Conversion of existing barns to 4 No commercial units (B1 use) and single dwelling (Departure from Development Plan)
Longfurlong Barns Longfurlong Farm Longfurlong (A280) Clapham

Thank you for consulting the Joint Committee on this application.

REVISION		DATE
PROJECT	Conversion of existing barn at Longfurlong Farm Patching	
DRAWING	Proposed Site Plan	
SCALE	DATE	DRG. No.
1:200		07 / 21 / 01
DRAWN	CHECKED	REV
		A

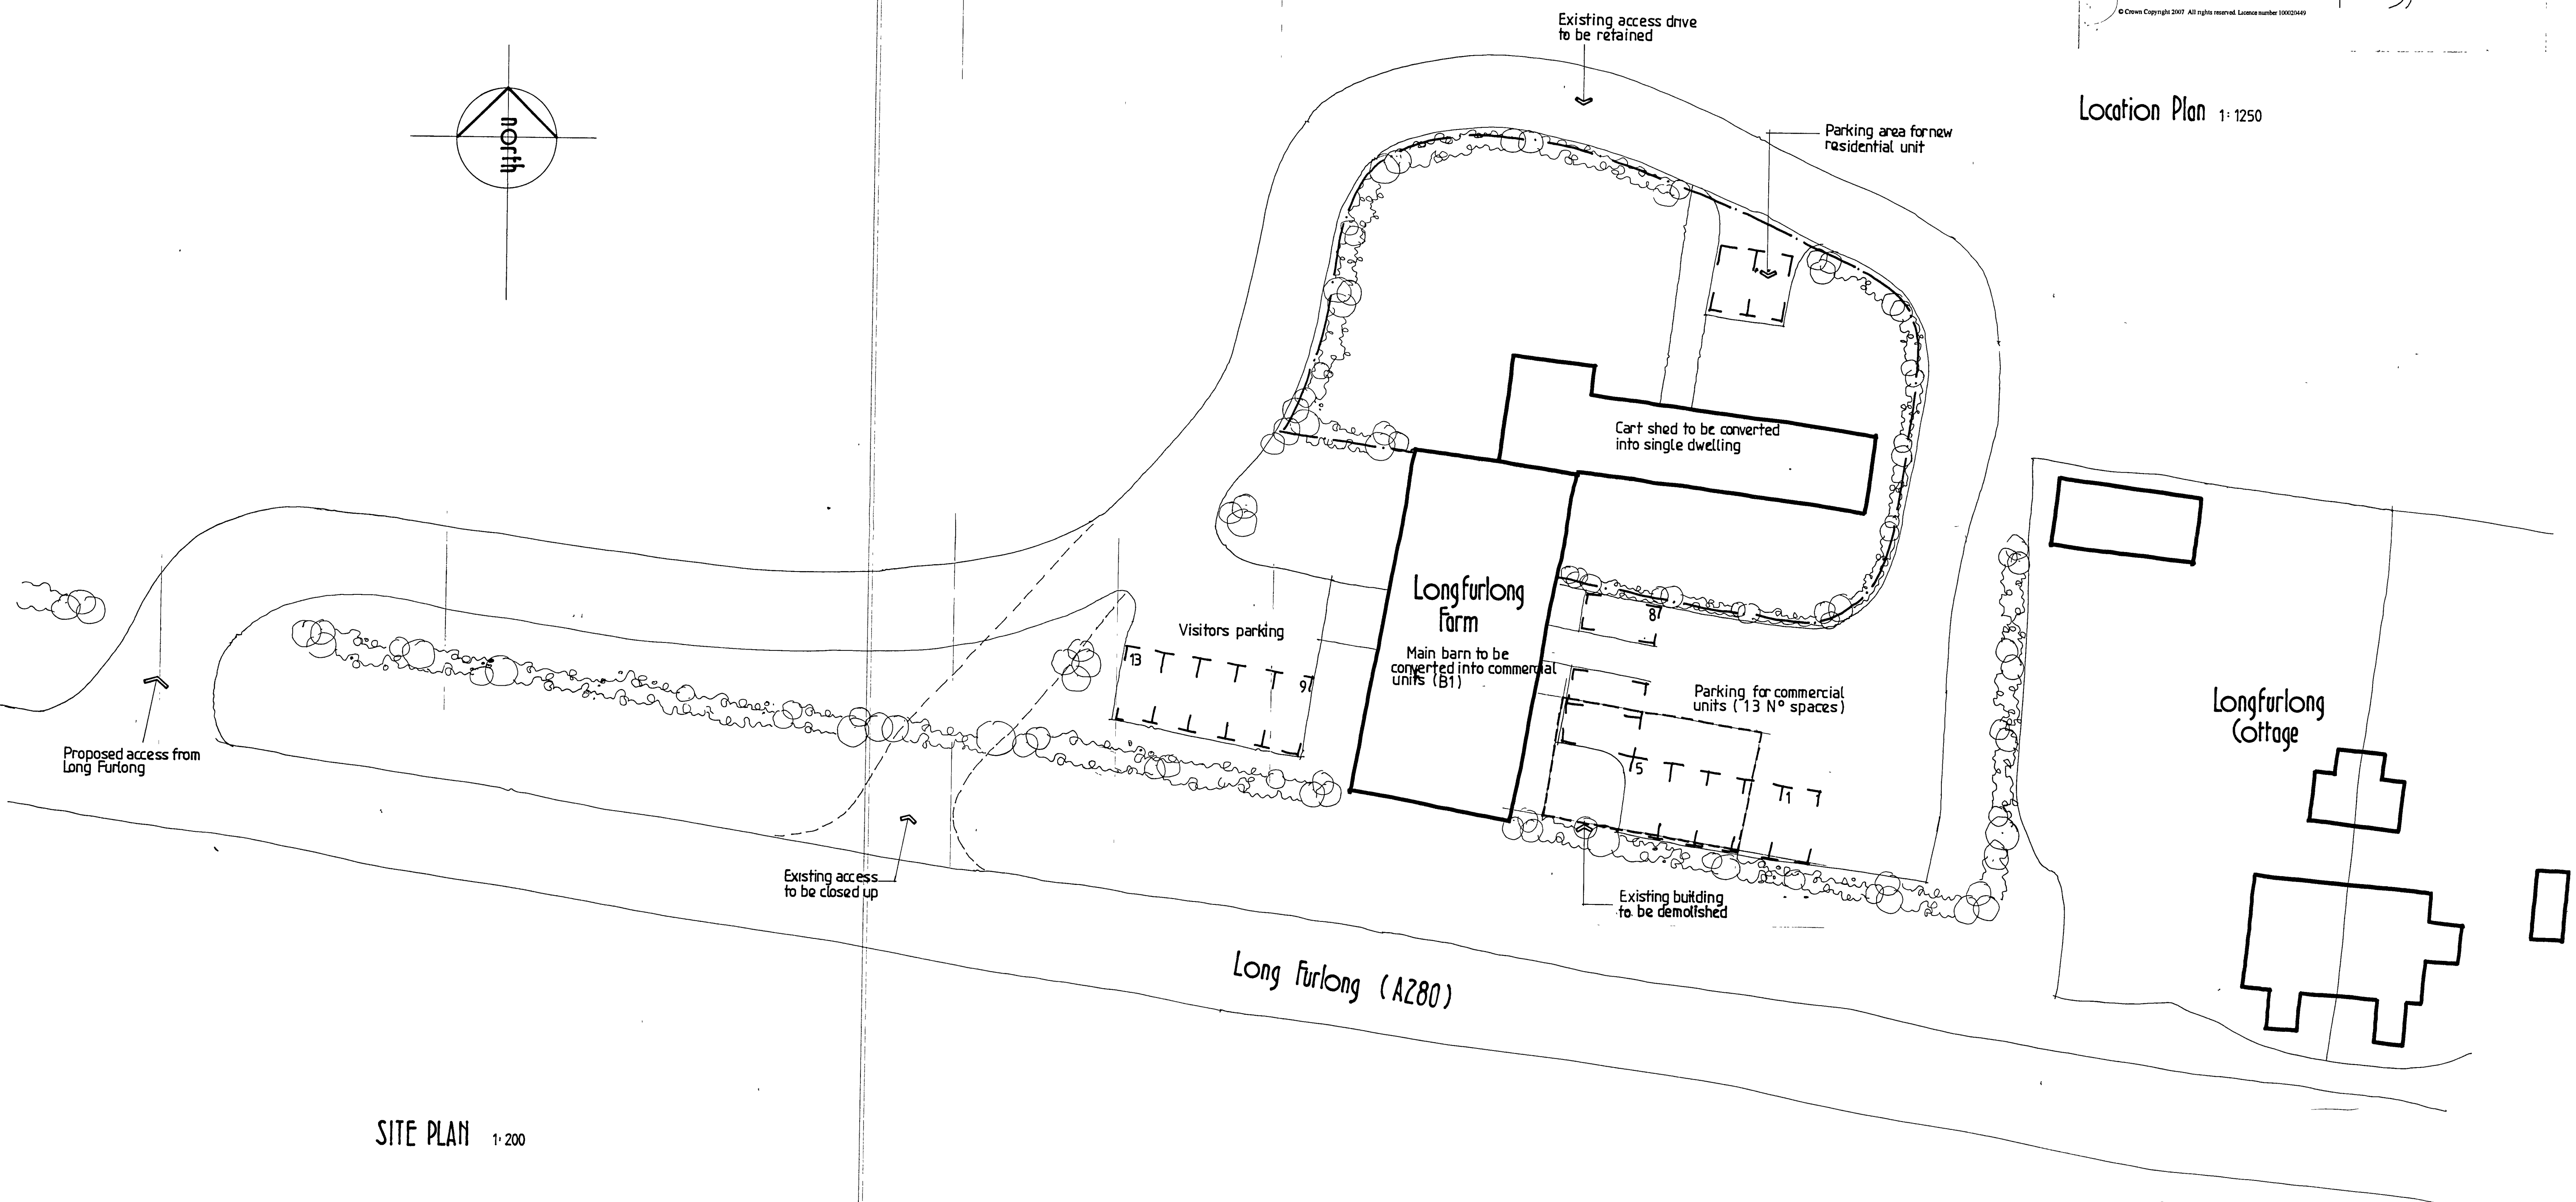
I am also unhappy with the proposed parking arrangement - I consider it important to maintain the open views of the western elevation of the barn and I therefore object to the proposed visitor parking area. I would prefer to see all parking contained in the area between the barn and the cartshed, even though that would necessitate all vehicles passing to the north of the buildings. Given my objection to the conversion of the cartshed as a dwelling, I wonder if it could be used to provide some parking.

incidentally, one of the development considerations is encouraging the sympathetic re-use of traditional farm buildings). The long-distance views of the barn make it a distinctive feature in the locality and, as noted above, I would like to see those open views maintained. Such expansive views are a characteristic of the open downland - whereas extensive planting is not. I would therefore prefer not to see the proposed hedge planting either alongside the A280 to the west of the barn or around the curtilage of the proposed dwelling (which, if it was not to be a dwelling, would be unnecessary). The proposed hedge to the east of the building is more acceptable, as it would screen the parking area and not block those longer-range views.
